29 March 2026

Edwina Ross
Senior Planning Officer
Dept. of Planning Housing and Infrastructure

Objection to DA SSD-93020230, 40-48 Redan St. Mosman

Level 3 Plan
GA Floor Plans

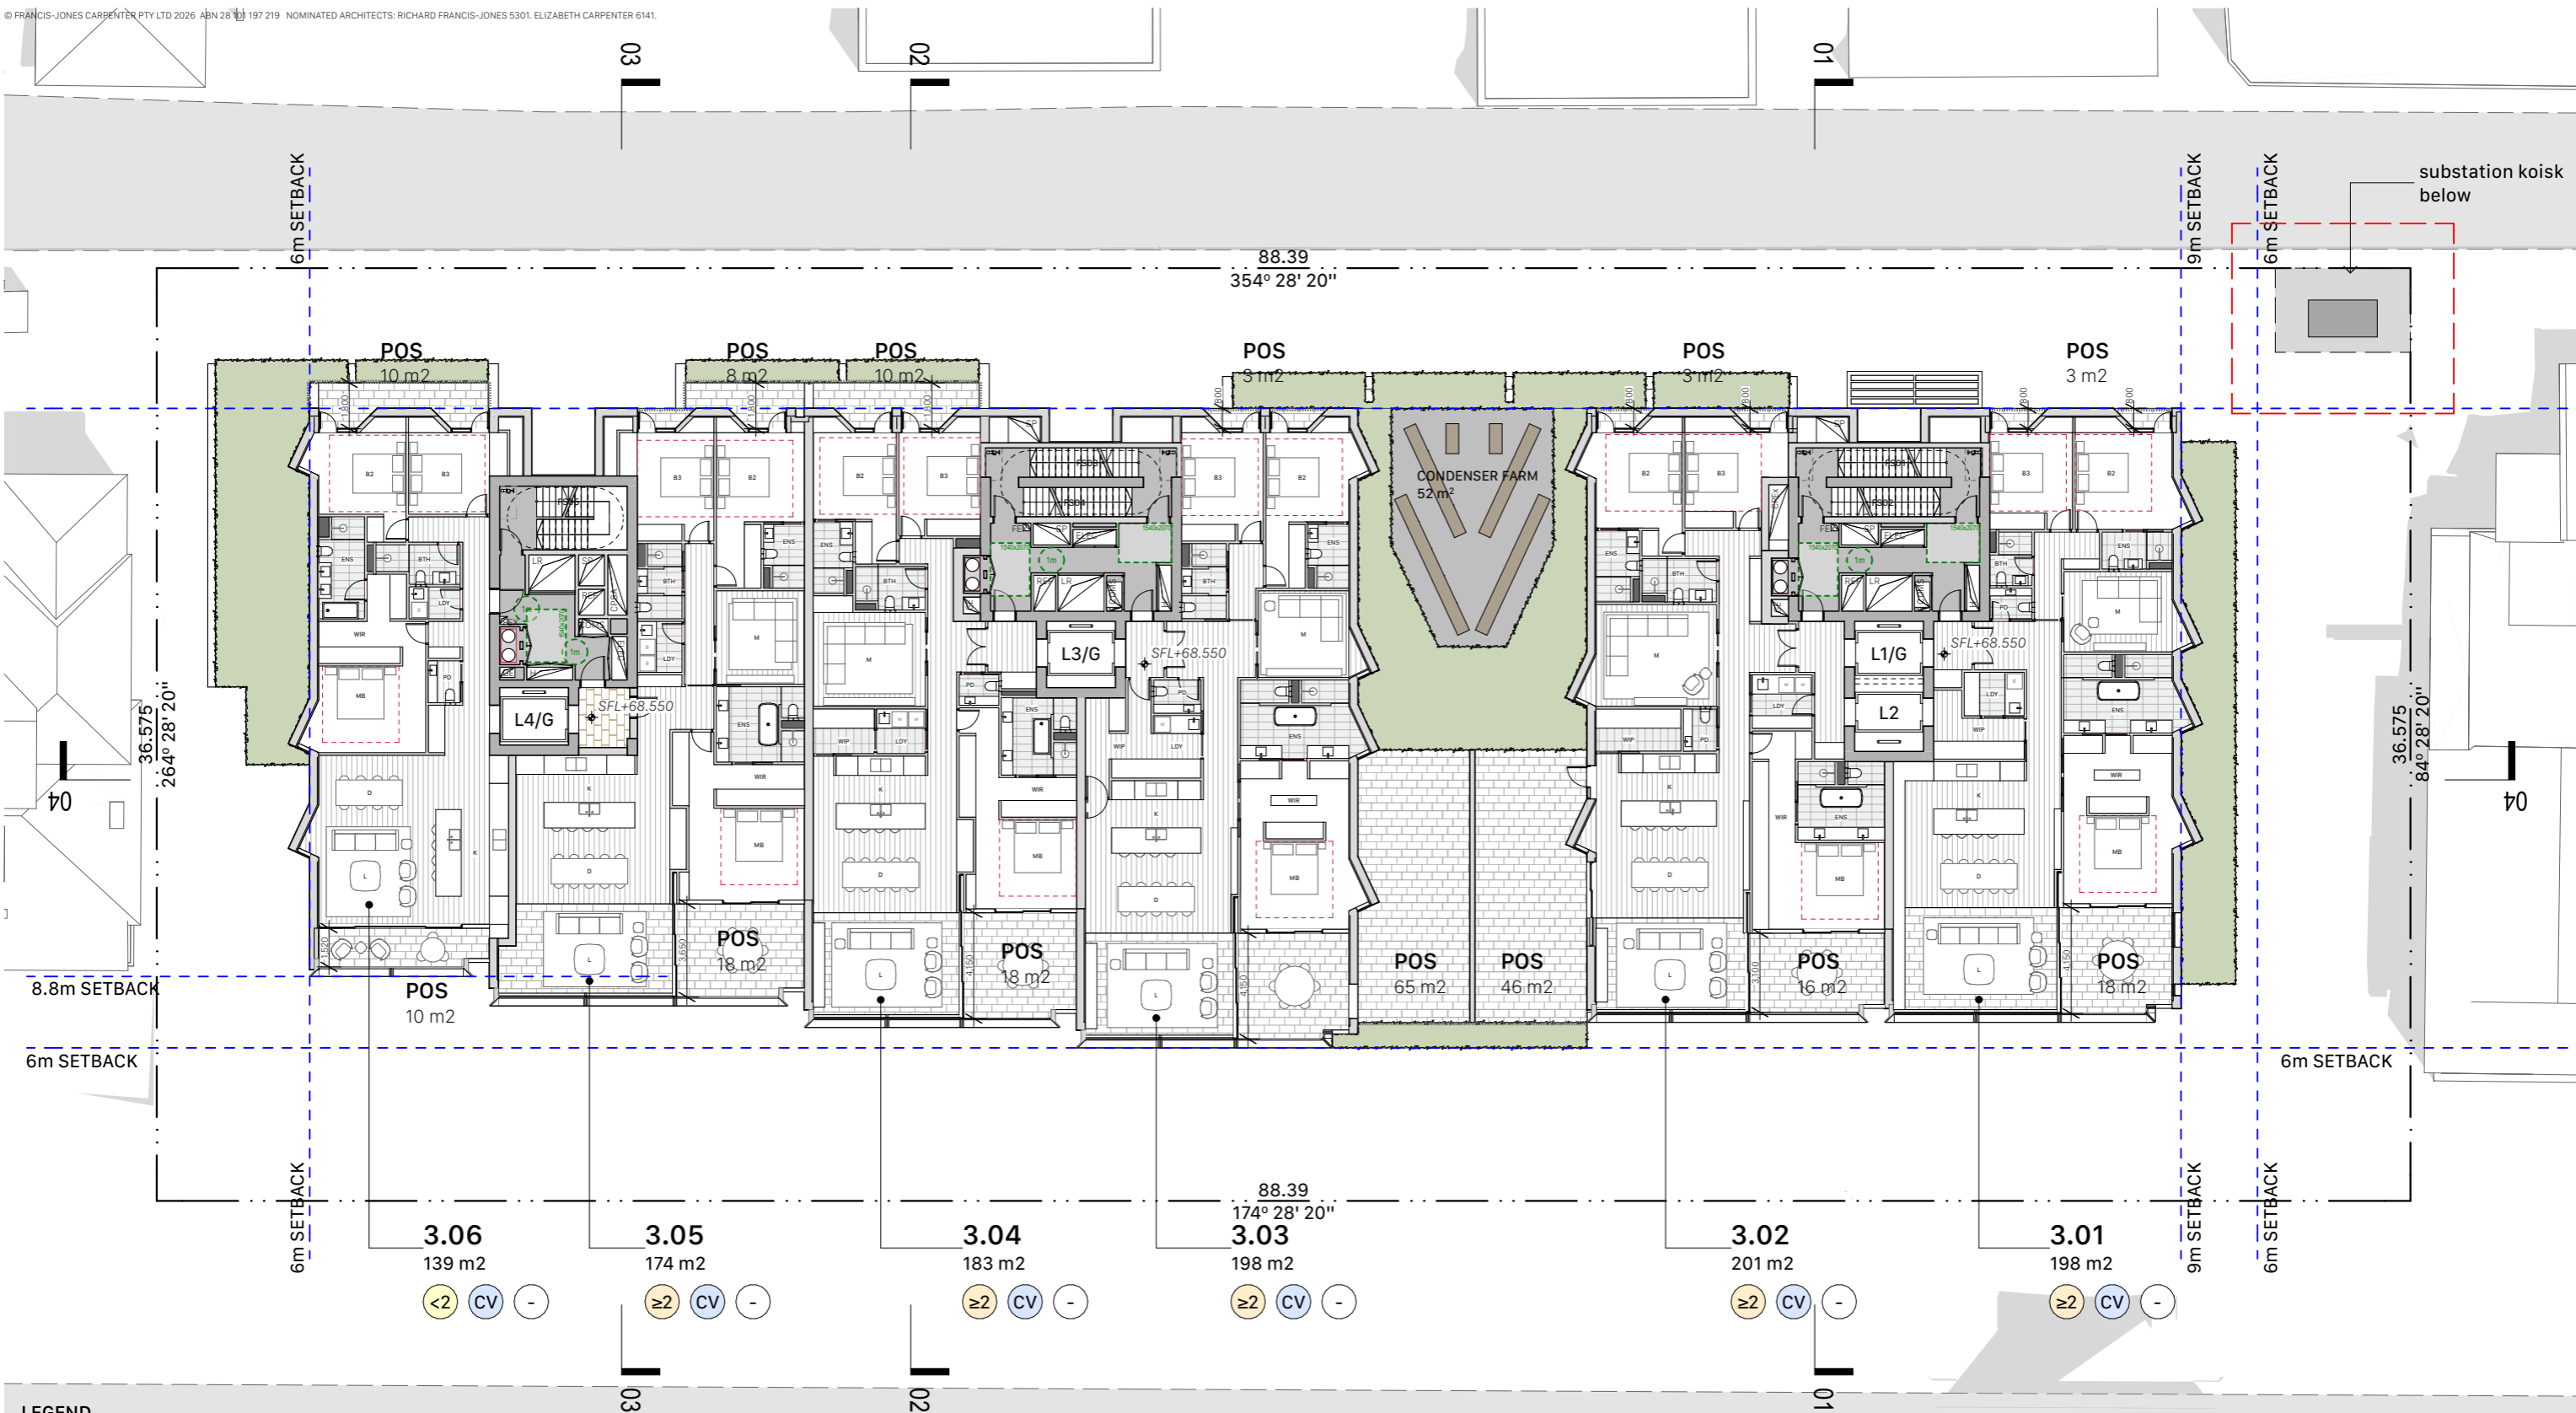
- d) The potential long term noise impact of the proposed “condenser farm” for air conditioning in the gap between buildings on level 3 is also of concern. The assessment of night time noise is dependent on a “night time mode” operation of the condensers. Since selection of this mode will presumably be at the option of the apartment owners, either individually or collectively, this cannot be relied on to maintain the amenity of nearby residents. Acoustic treatments should be required to meet the relevant emission requirements independently of any action by the apartment owners.
- e) We have been unable to find any assessment of the potential impact of dust created during construction, especially during the demolition and excavation stages.
